An
Bord
Pleanála

Inspector's Report ABP-312523-22

Whether the Drawing No. DoE3, elevations/fenestration pattern is materially consistent with the granted Planning PP/13/94 & 18/178 Extension of duration, is or is not development and is or is not exempted development.

63 Threadneedle Road, Salthill, Galway

East Elevation - Rear Garden - Declaration of Exemption 2021
1:100

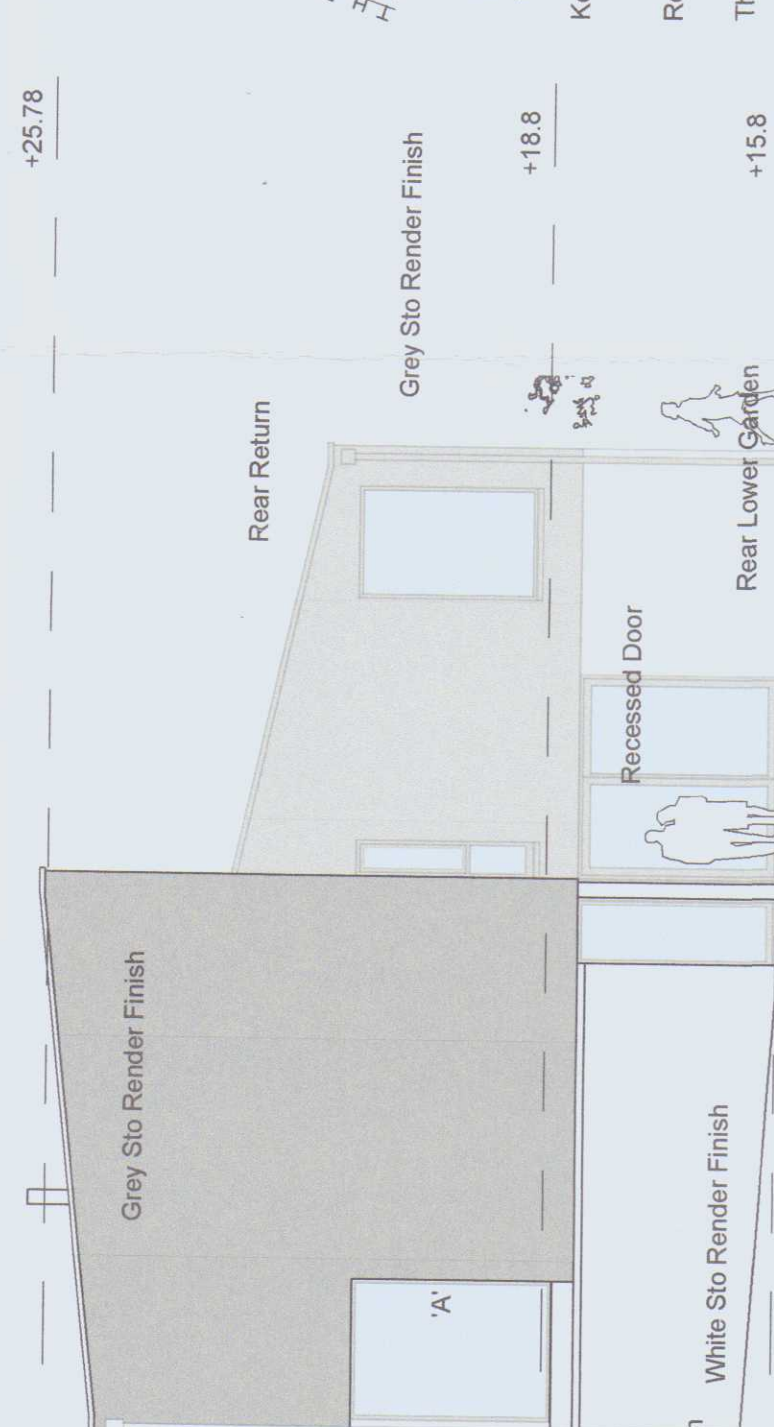
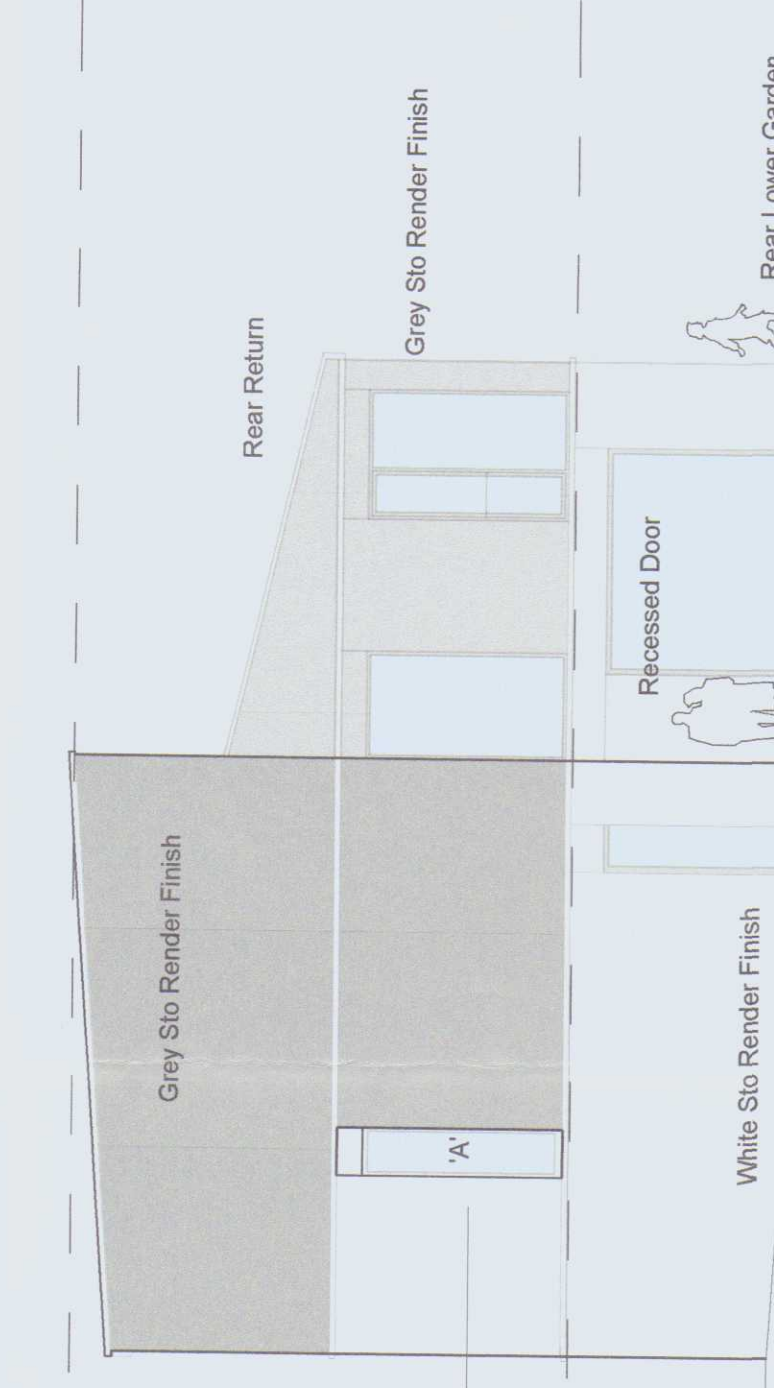
East Elevation:

- Changes to size and location of windows on all floors, the omission of a window at first floor level and enlarged window at first floor level.

South Elevation - to South Boundary - Declaration of Exemption 2021
1:100

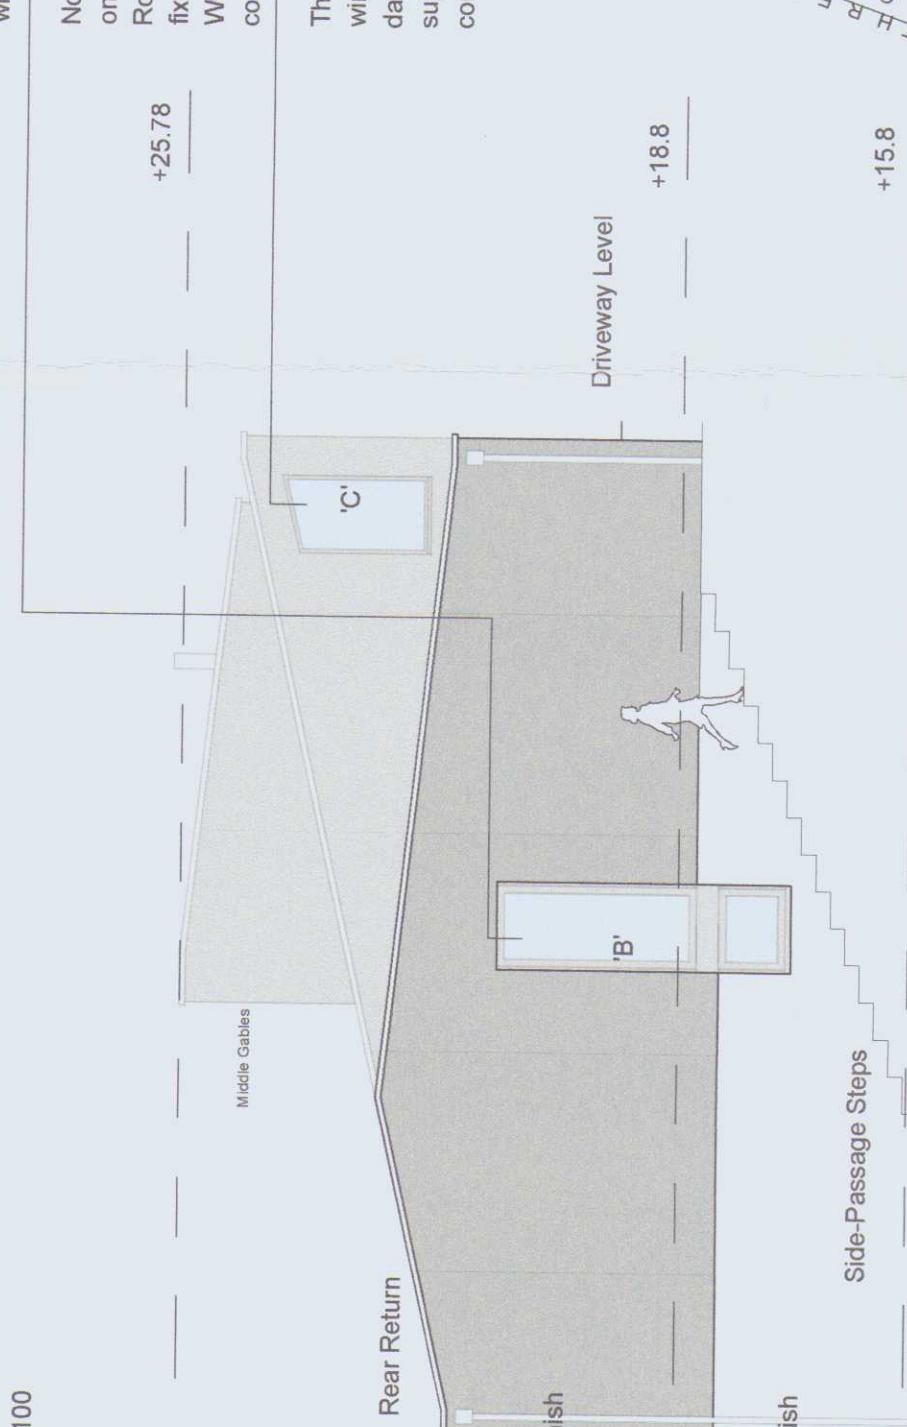
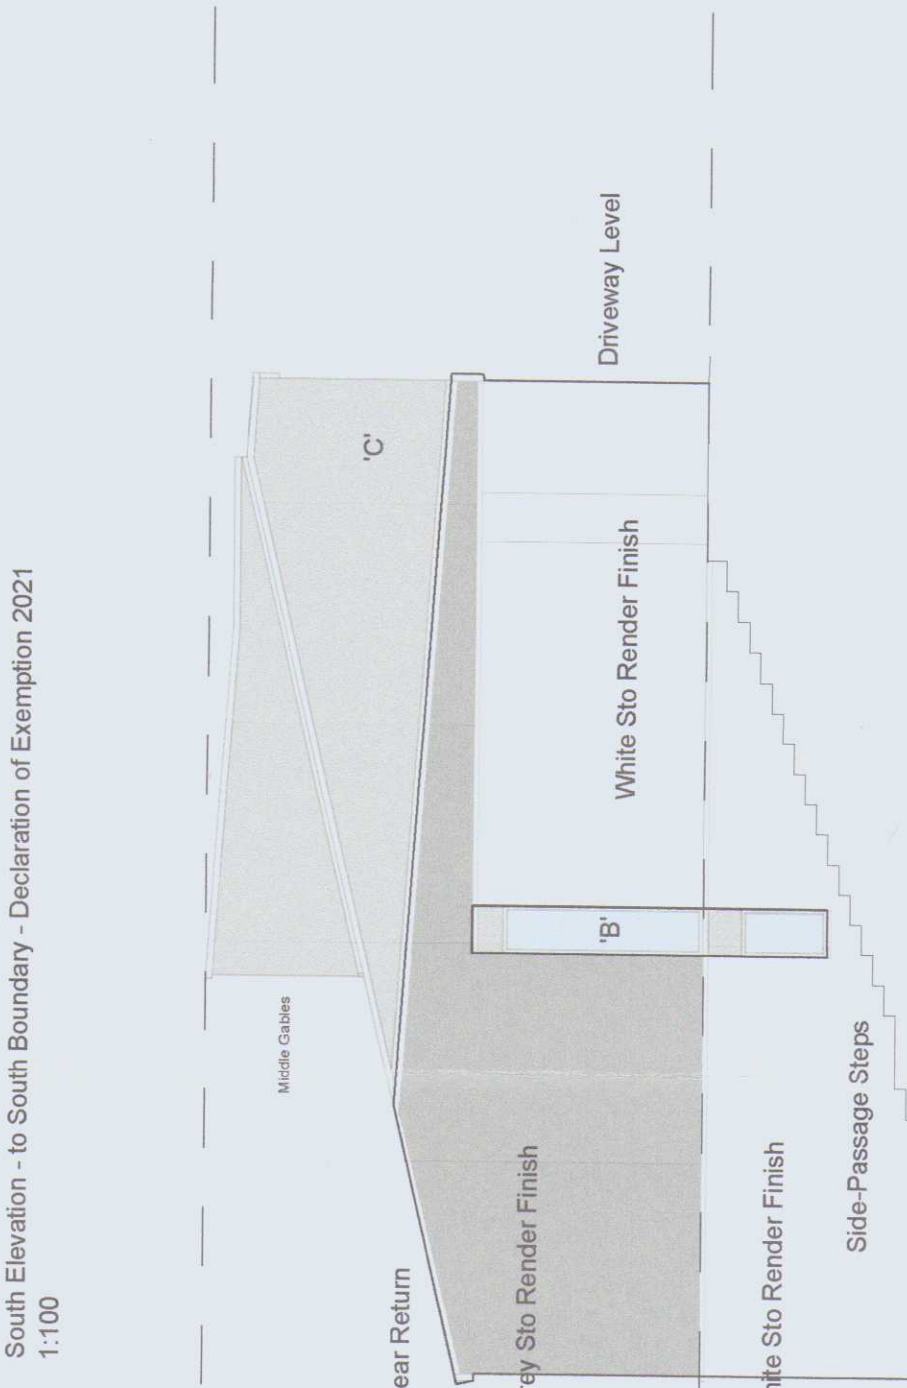
- 2.3. Details of the changes are as follows;
 - South Elevation (Window 'A'):
 - permitted window c. 1.8 m x c. 2.5 metres v as constructed c. 0.5 metres x c. 2.6 metres. 'Window A' is a fixed pane, non-opening window with translucent glass, serving a WC.

- 'Window A' cannot be considered 'de minimis', and contravenes Condition No. 1 of PA. Ref. 13/94. Article 9 (1) (a) (i) of the Planning and Development Regulations, 2001, as amended, limits exempted development.

- 'Window A' as permitted served a void and did not result in any overlooking.

North Elevation - to North Boundary - Declaration of Exemption 2021
1:100

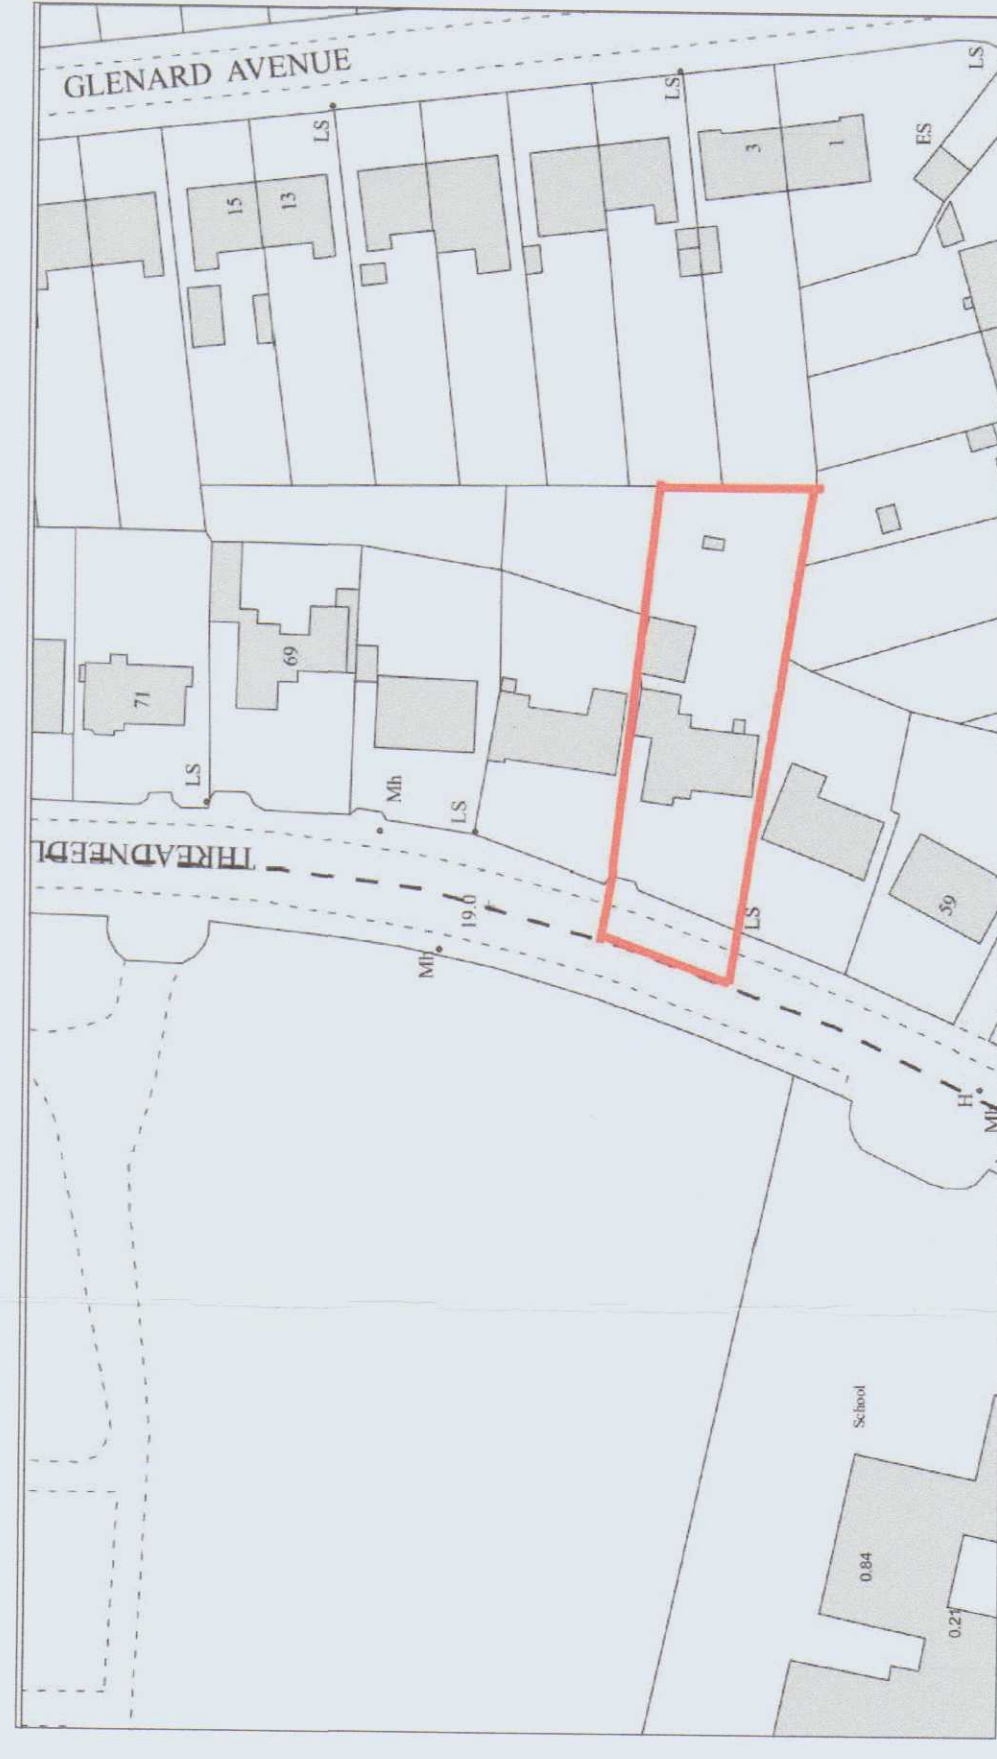
North Elevation (Windows 'B' & 'C')

- permitted window c. 1.2 m x c. 1 metre and c. 1.2 metres x c. 2.5 metres v as constructed c. 0.5 metres x c. 1 metre and c. 0.5 metres x c. 2.5 metres. 'Window B' is a fixed pane, non-opening window with translucent glass.
- Omission of high level window ('Window C').
